Our ref: NO/2020/112855/05-L01
Your ref: 3/2020/0601
Date: 18 February 2021

**OUTLINE PLANNING FOR THE CONSTRUCTION OF UP TO 125 DWELLINGS WITH PUBLIC OPEN SPACE, LANDSCAPING AND SUSTAINABLE DRAINAGE SYSTEM AND VEHICULAR ACCESS POINT FROM HIGHMOOR PARK. ALL MATTERS RESERVED EXCEPT FOR MEANS OF ACCESS.
LAND AT HIGHMOOR FARM, CLITHEROE, BB7 1PN**

We have reviewed the revised FRA submitted with the application referenced below;

Flood Risk Report Rev. F, by Topping Engineers ref. 18522, dated Jan 2021

Drawing title: Flow Exceedance Plan

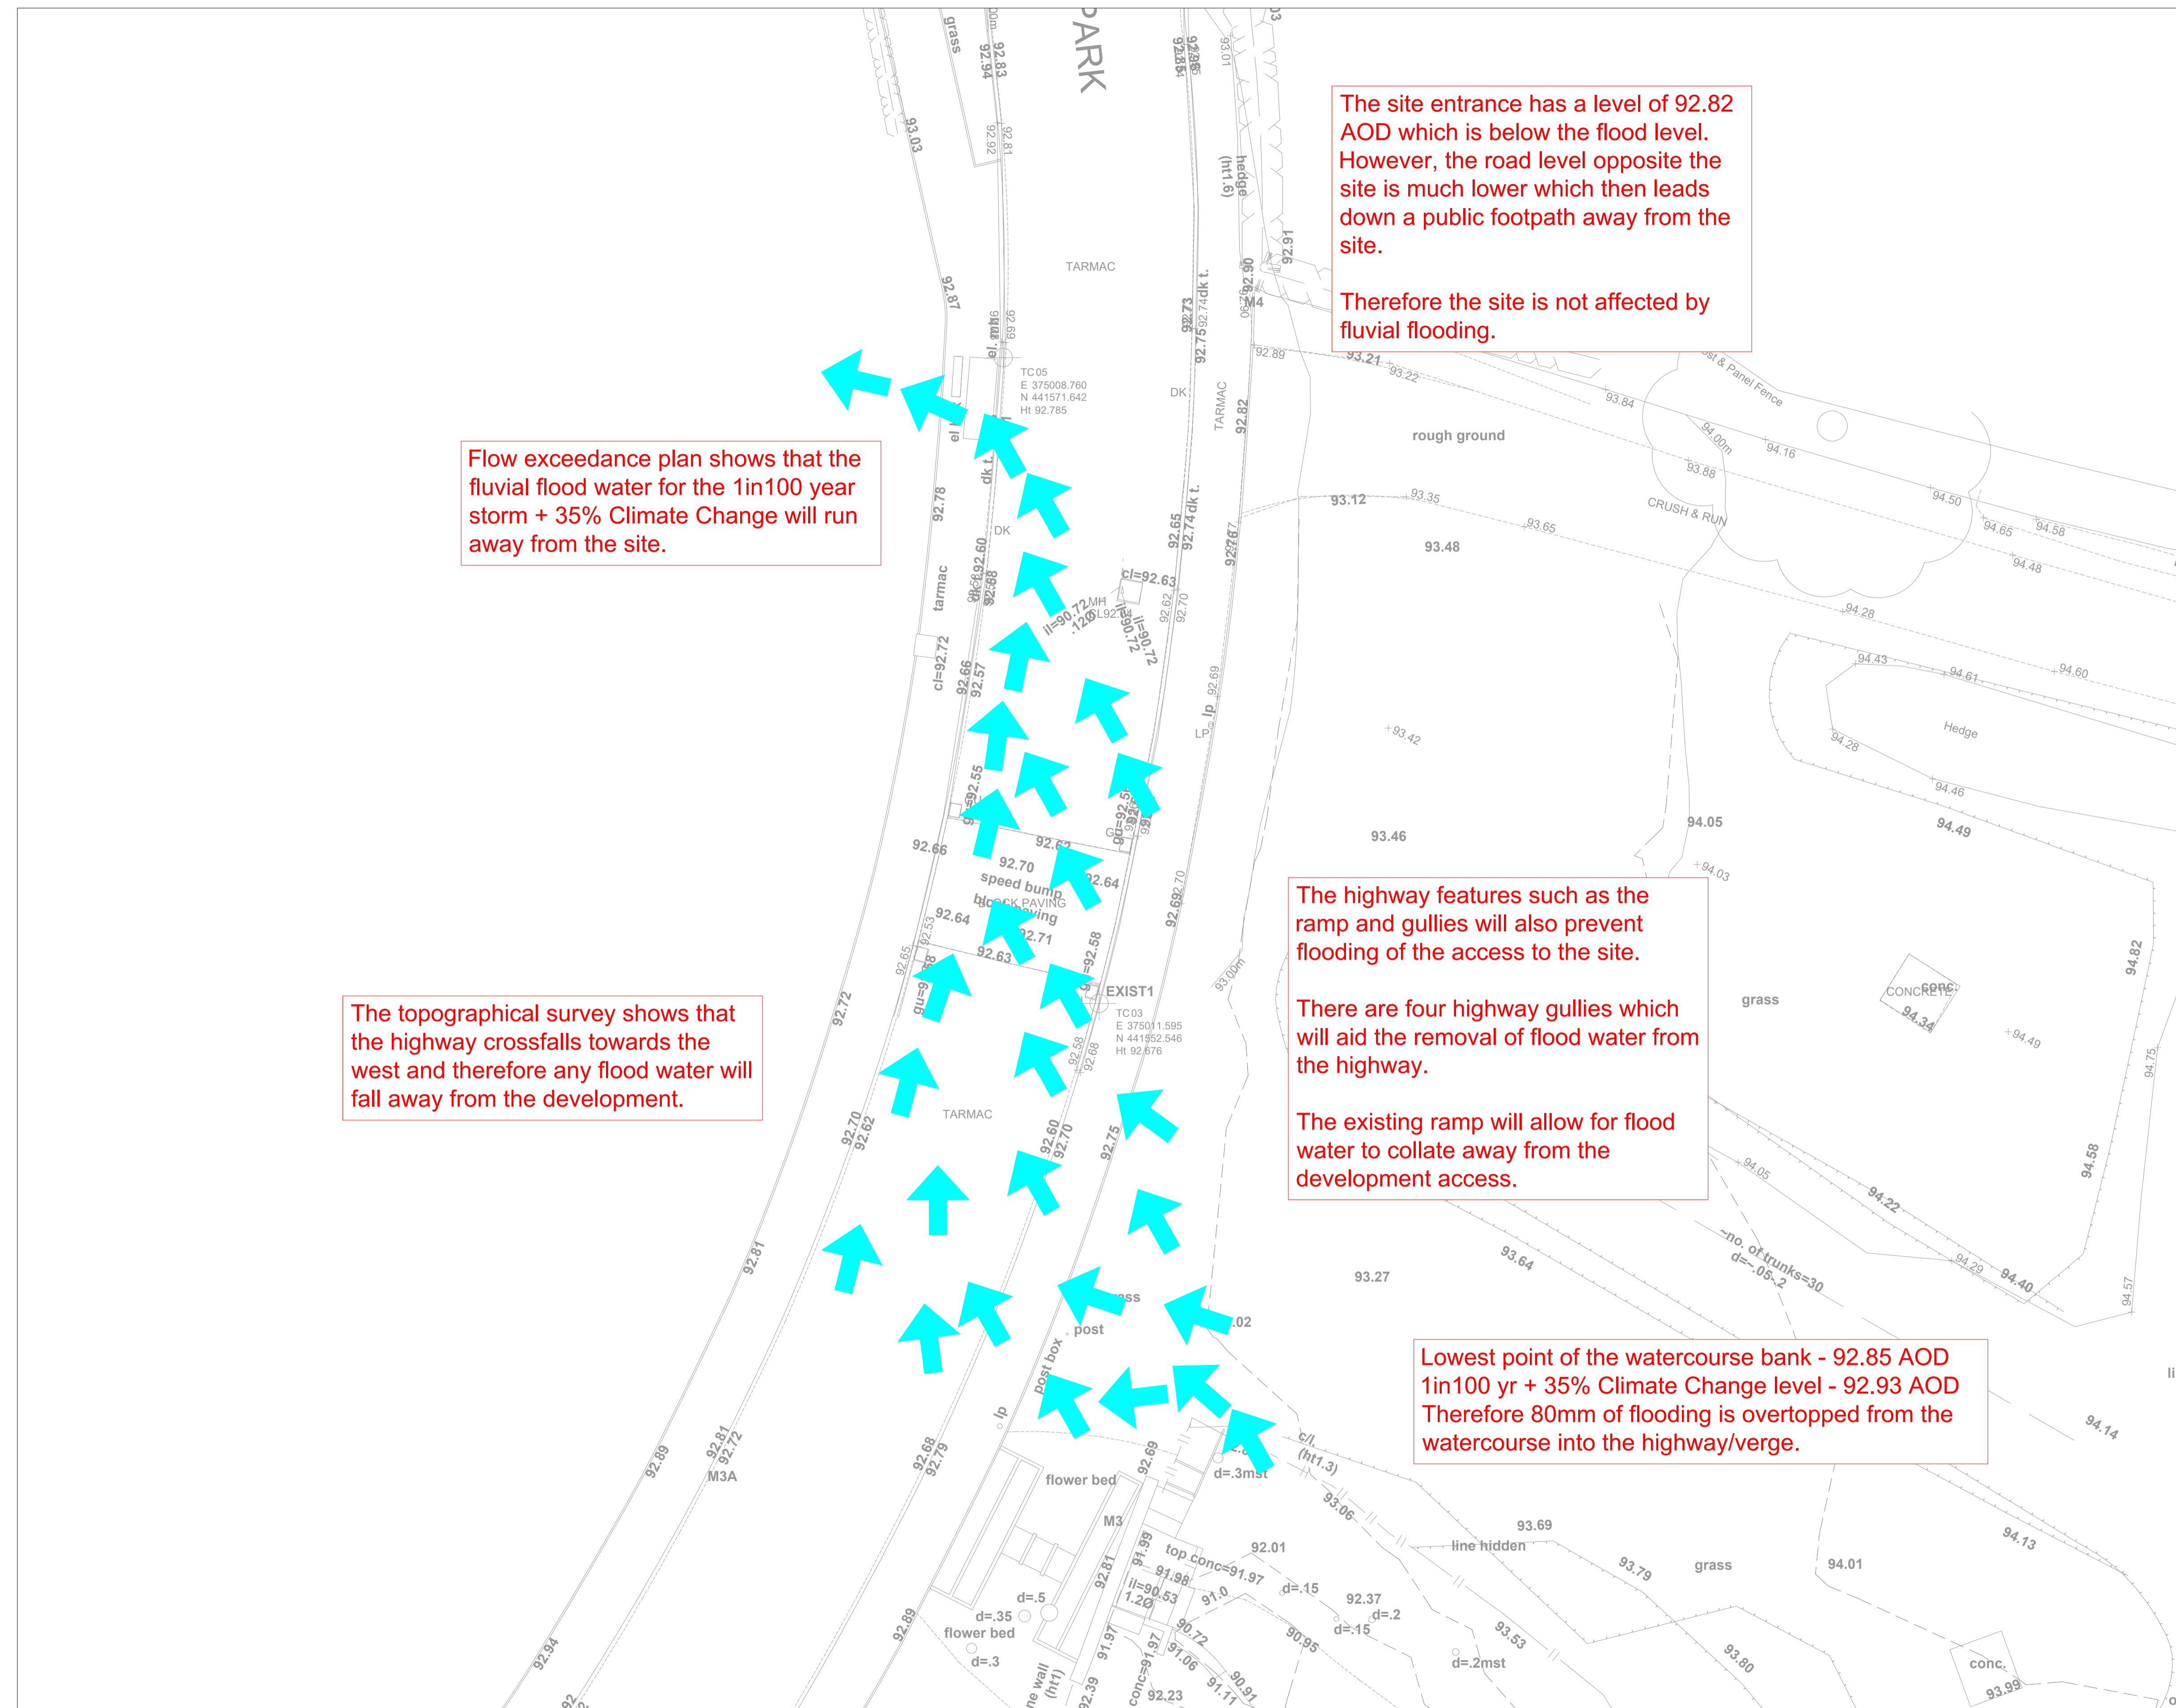
The FRA states in section 2.3, that there will be no built development within the flood zone. There is a small area of flood risk at the entrance to the site that the developer proposes to manage as part of the proposal. Measures to manage areas of flood risk must not raise ground levels within the Q100 plus climate change flood extent. We therefore have no objection to the proposal subject to the inclusion of the following planning condition

No ground levels within the 100-year return period plus 35% allowance for climate change extent of Shaw Brook will be raised, unless otherwise approved in writing by, the local planning authority.
